18 June 2020

**Re: Interim Audit Advice No. 1**  
**Proposed Remediation – Upper Fort Street, Observatory Hill, Millers Point**  
**NSW**

## **Re: Interim Audit Advice No. 2**

Capping Layer Layout with New Trees (0.5m Option)

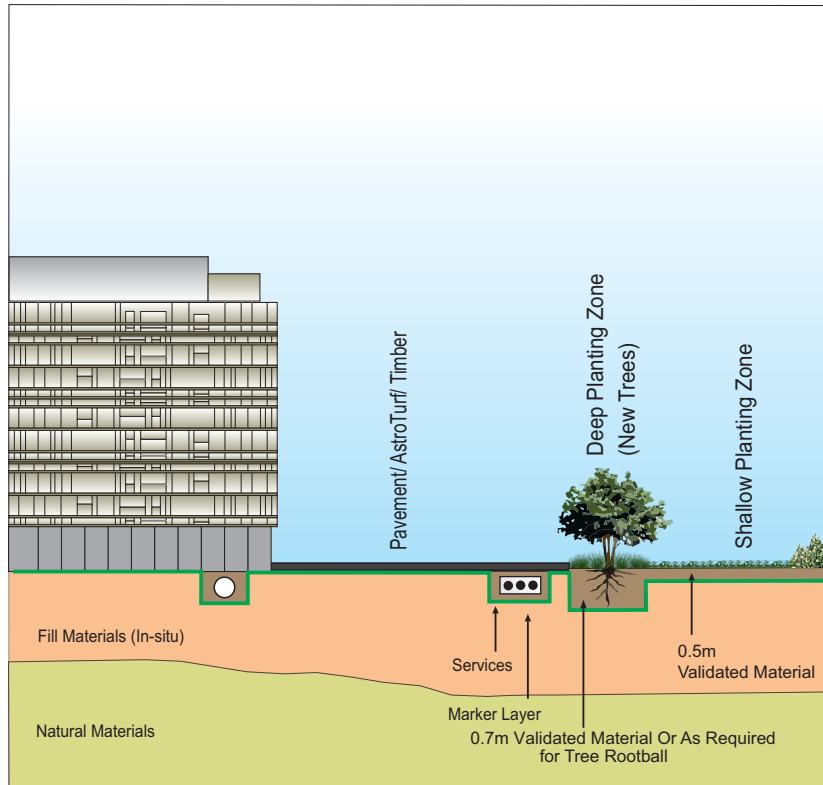
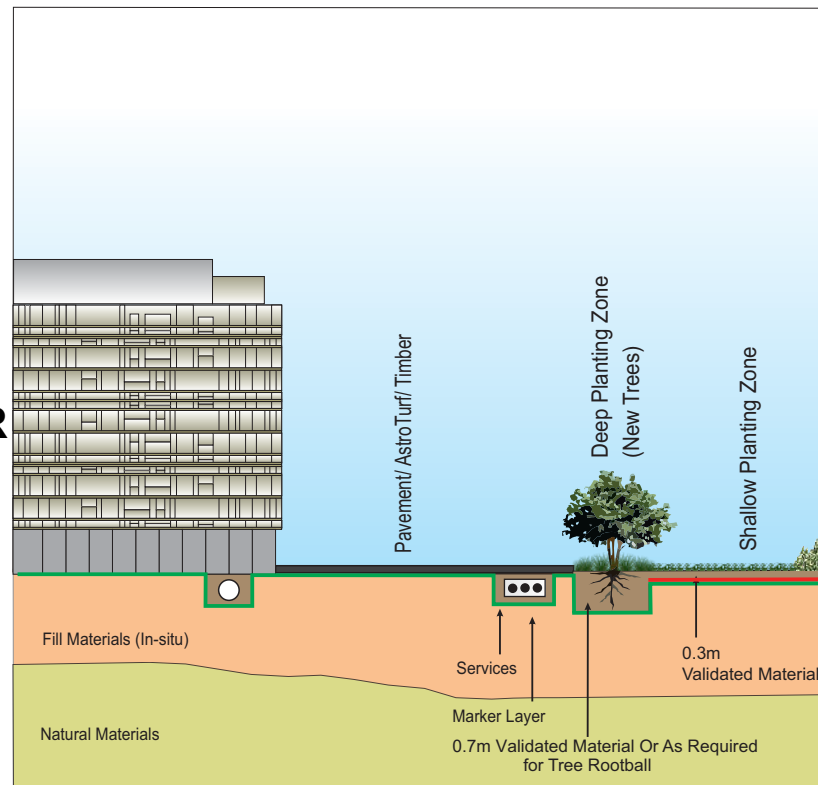
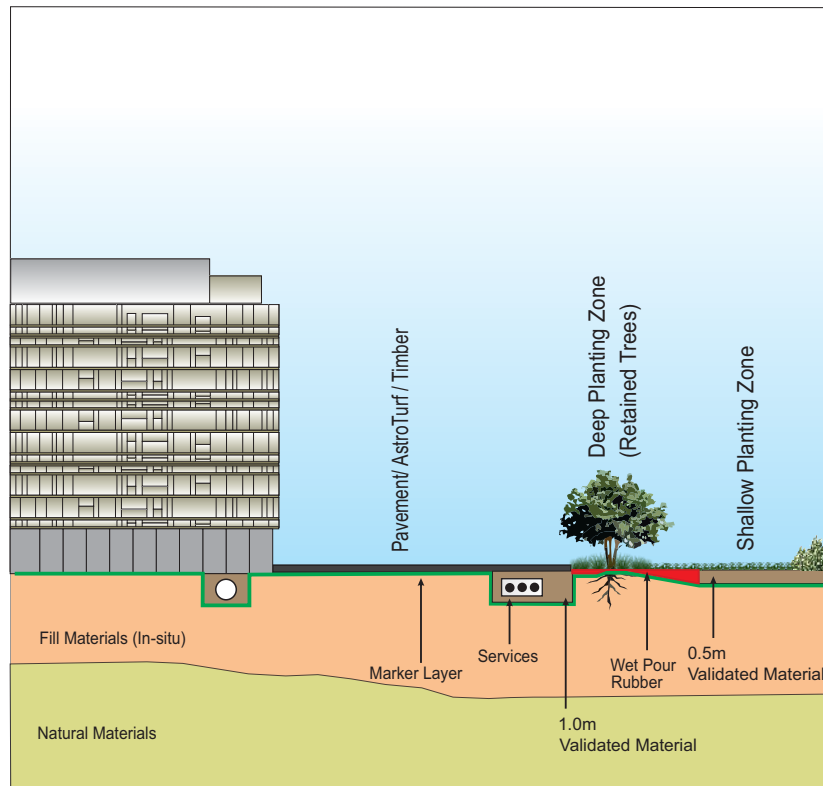
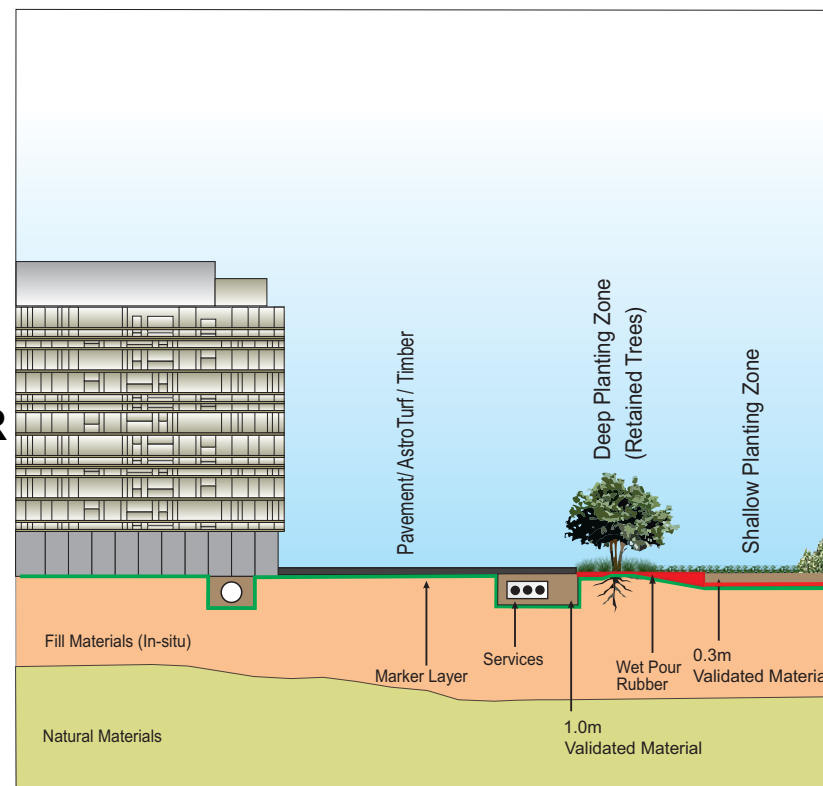
- Please ensure capping depths are consistent with standard practice i.e. 0.5 m grasses/shrubs and 1.2 m for trees.
- An asphalt layer was noted in five locations (only two were sampled and submitted for analysis) that is associated with particularly elevated concentrations of total polycyclic aromatic hydrocarbons (PAHs). Please confirm that this layer will be segregated from the fill material during earthworks and disposed off-site.
- Fill encountered at TP1B appears in consistent with other fill material over the site and is reporting particularly elevated concentrations of PAHs. Consideration should be given to segregating this material for off-site disposal.

- Capping designated for pavers only appropriate where the pavers cannot be lifted.
- Capping proposed in landscaped areas is inappropriate i.e. 0.1-0.2 grasses and shrubs should be 0.5 m and 0.7 m for trees should be 1.2 m (subject to tree types proposed).
